Meeting note

File reference	EN010068
Status	Final
Author	Karl-Jonas Johansson
Date	6 March 2015
Meeting with	Millbrook Power Limited
Venue	Temple Quay House, Bristol
Attendees	Applicant (Millbrook Power Limited) Nick Johnson, STAG energy Paul Wormald, Peter Brett Consultants Richard Griffiths, Pinsent Masons Planning Inspectorate Ken Taylor (Infrastructure Planning Lead) Vicki Hodgson (Legal) Kay Sully (Case Manager) Karl-Jonas Johansson (Case Officer)
Meeting objectives	Draft Documents meeting
Circulation	All attendees

Comments on the Millbrook Power Draft DCO

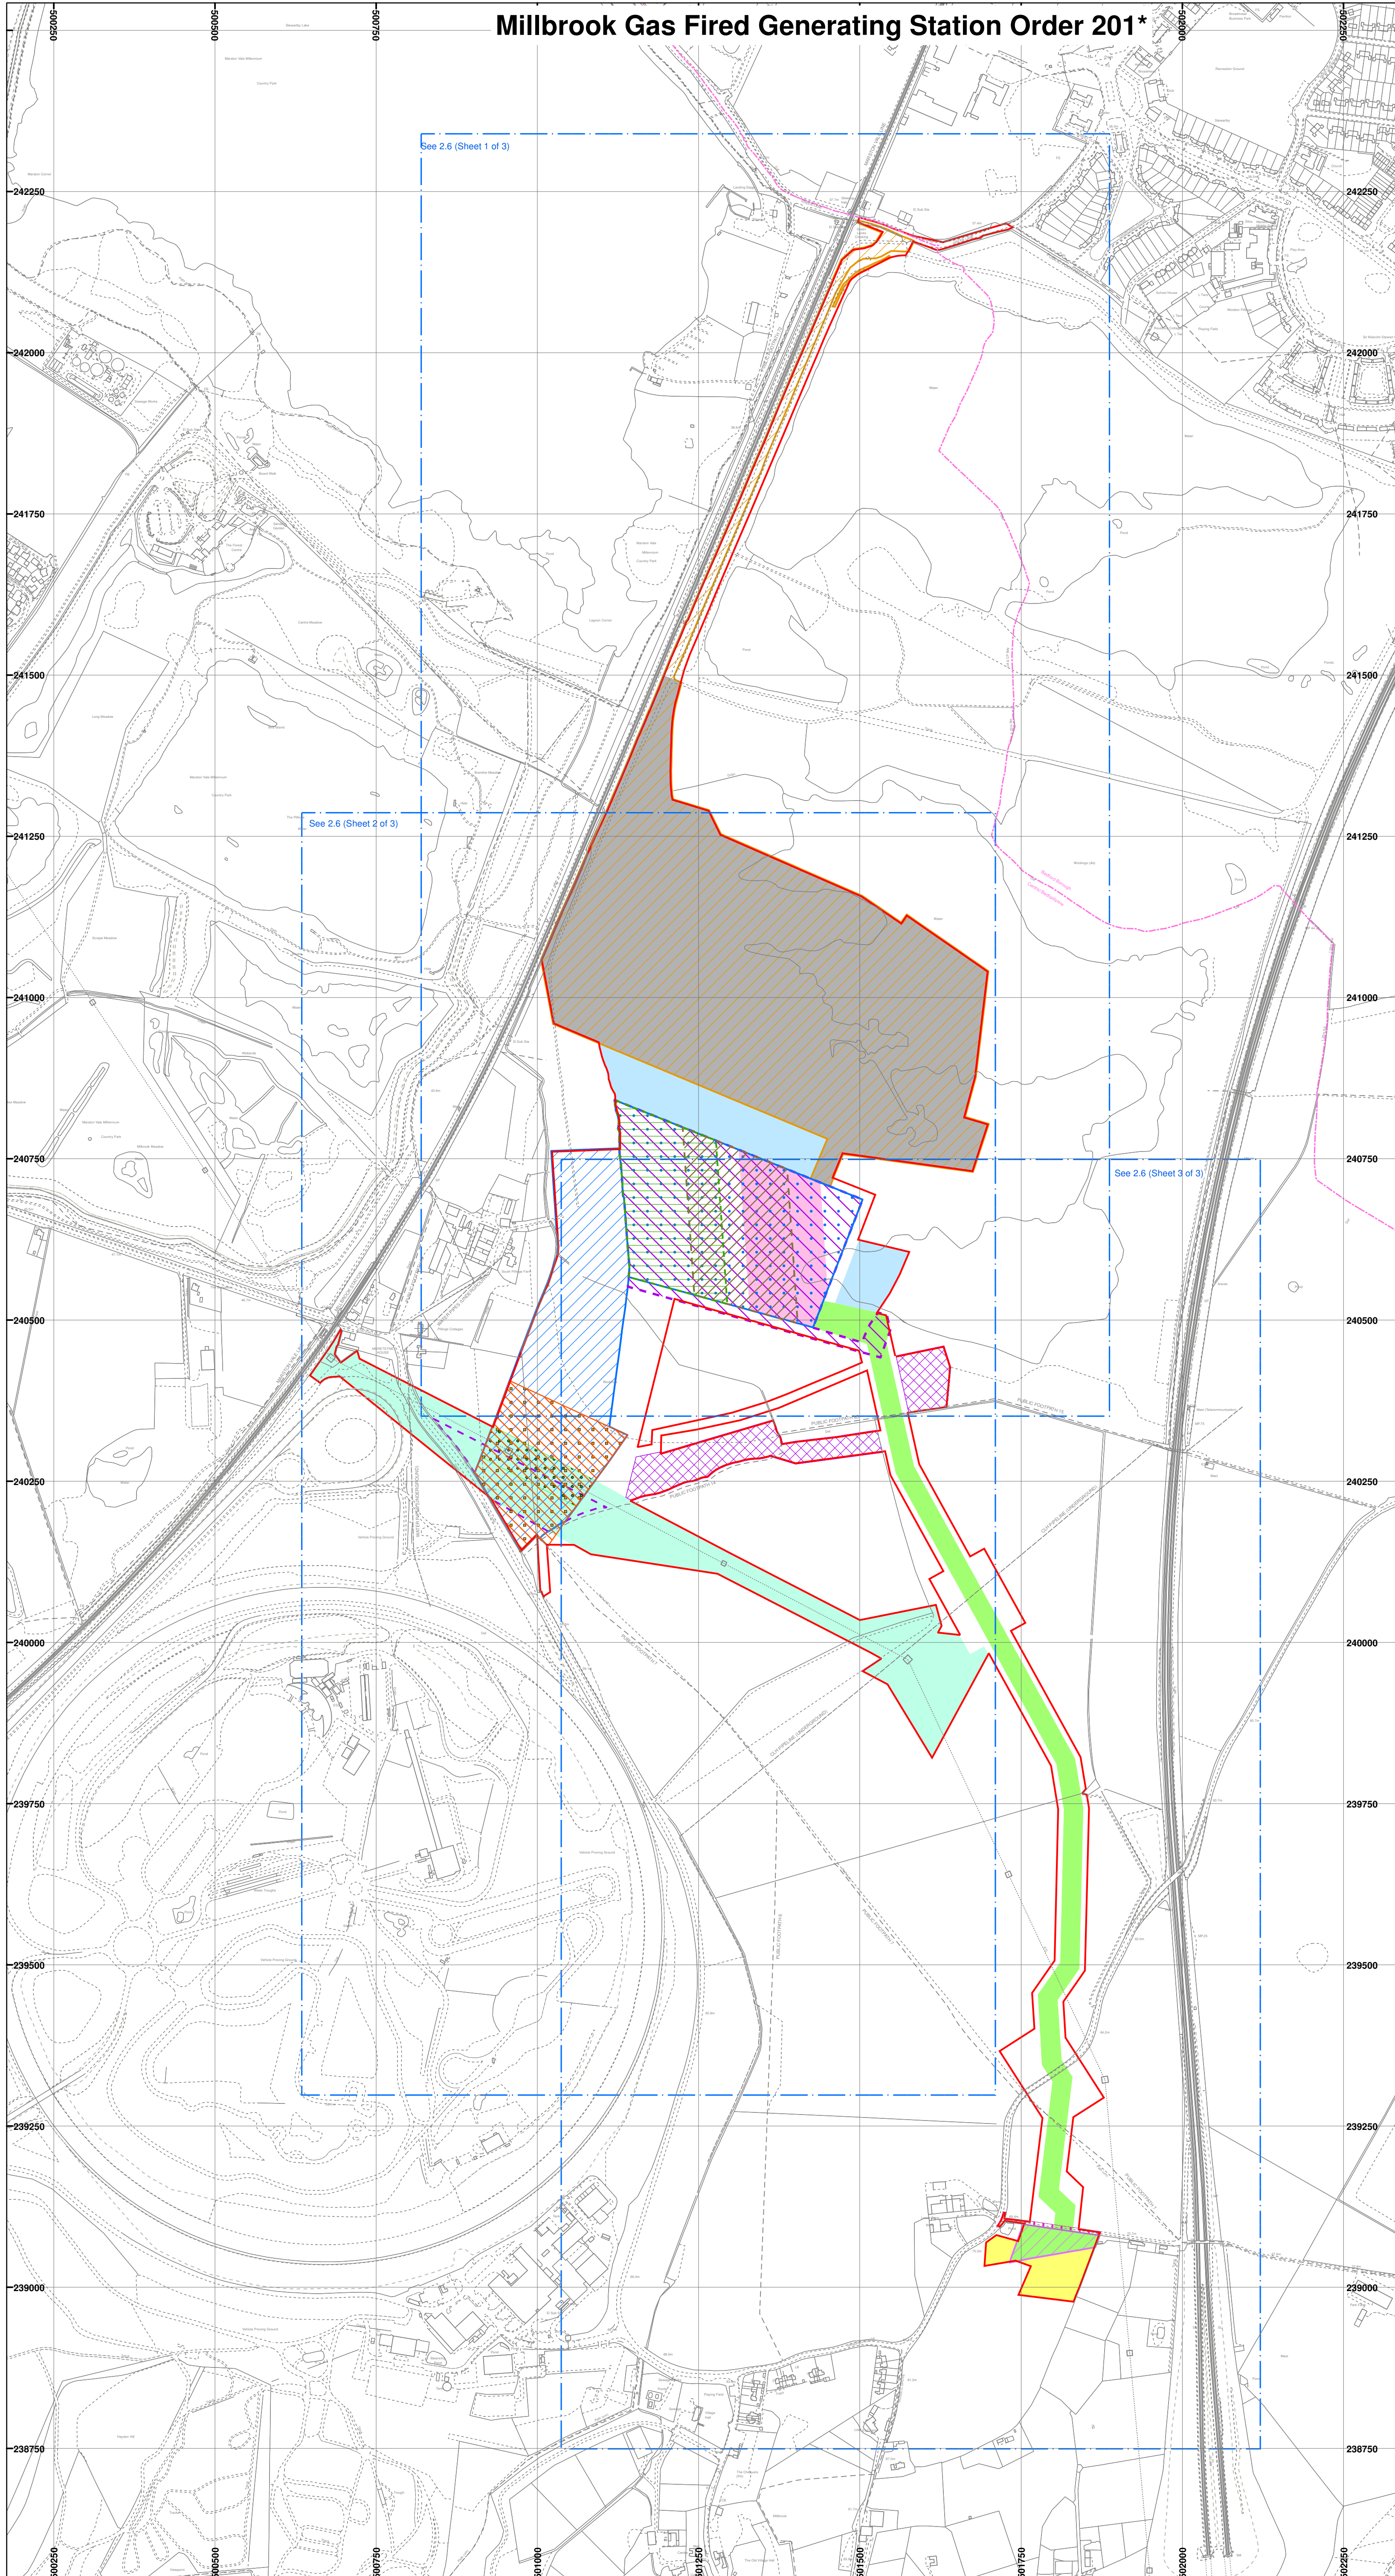
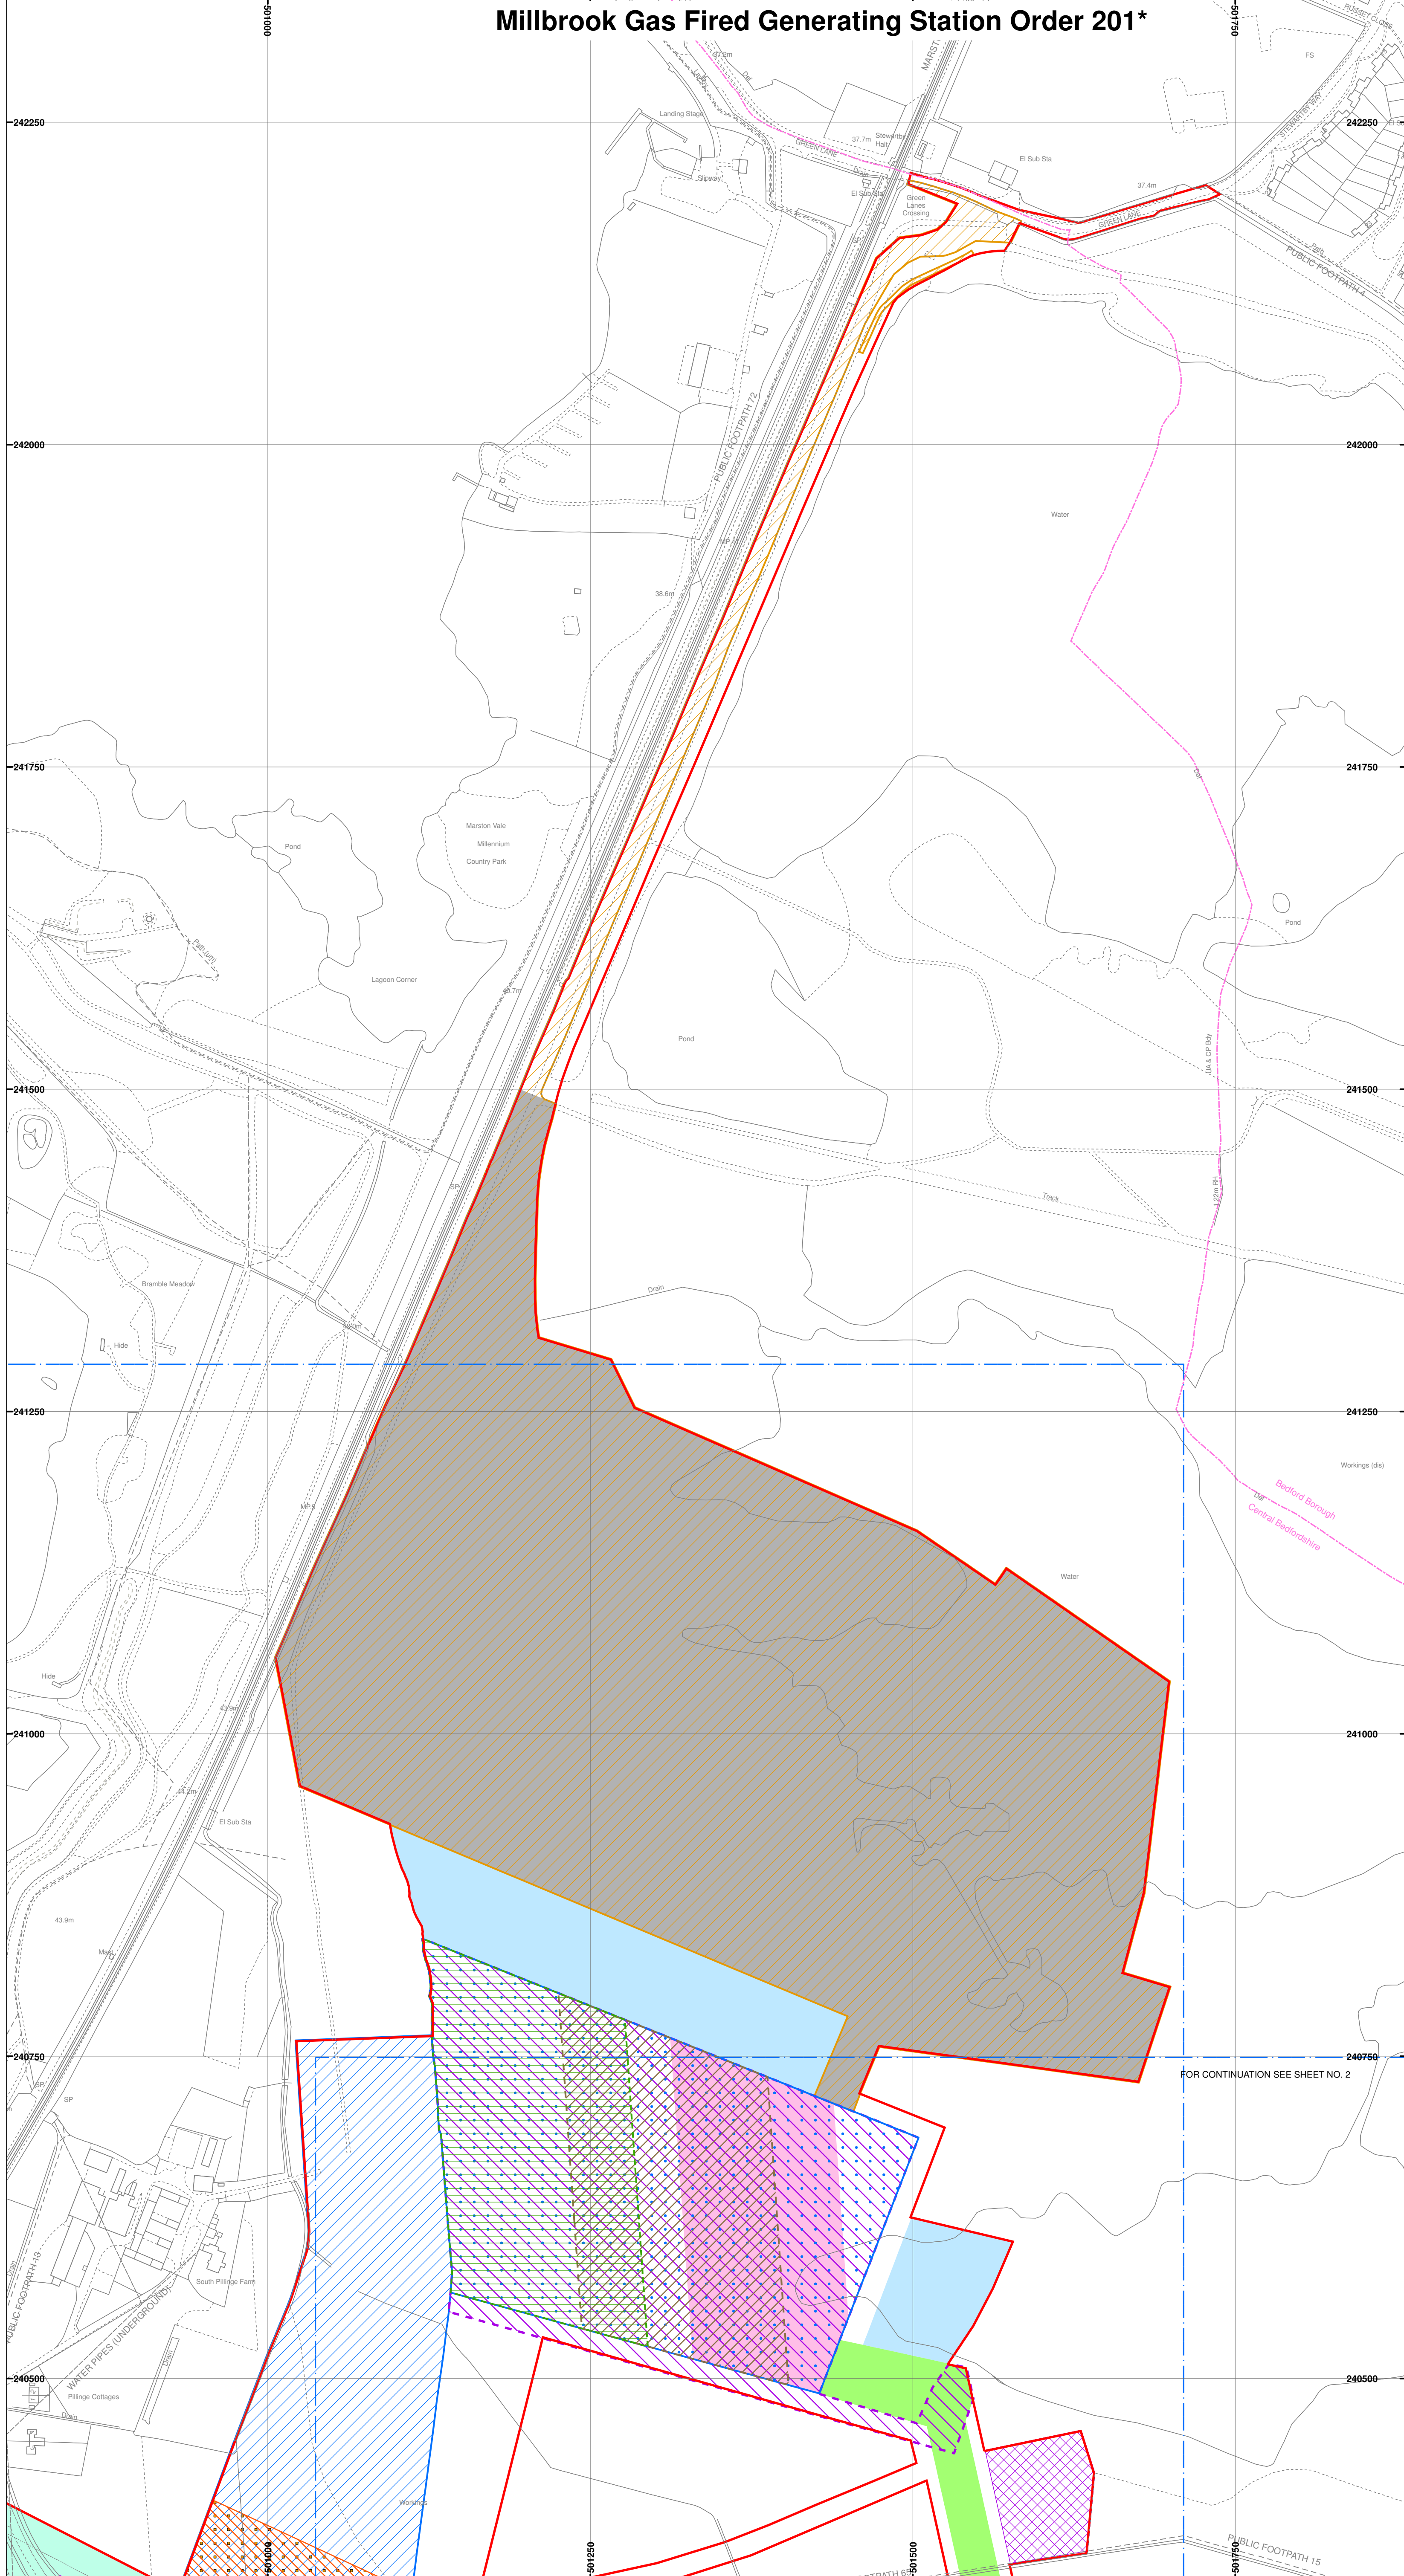
The applicant explained that the updated version of the DCO addressed the issue of some the works not being controlled in the previous version of the DCO. It was agreed that the applicant would check if works 1b, 1d and 3a was fully controlled in the updated version of the DCO. The applicant clarified that works 6a and b could be seen on the indicative layout plan but not on the works plans.

Work 6 – it is not immediately apparent why there are two options for Work 6. Are these in different locations (i.e. the northern and southern dotted areas on the Land Plans?) If so it may be helpful to annotate which is area 6A and 6B on the Land Plans.
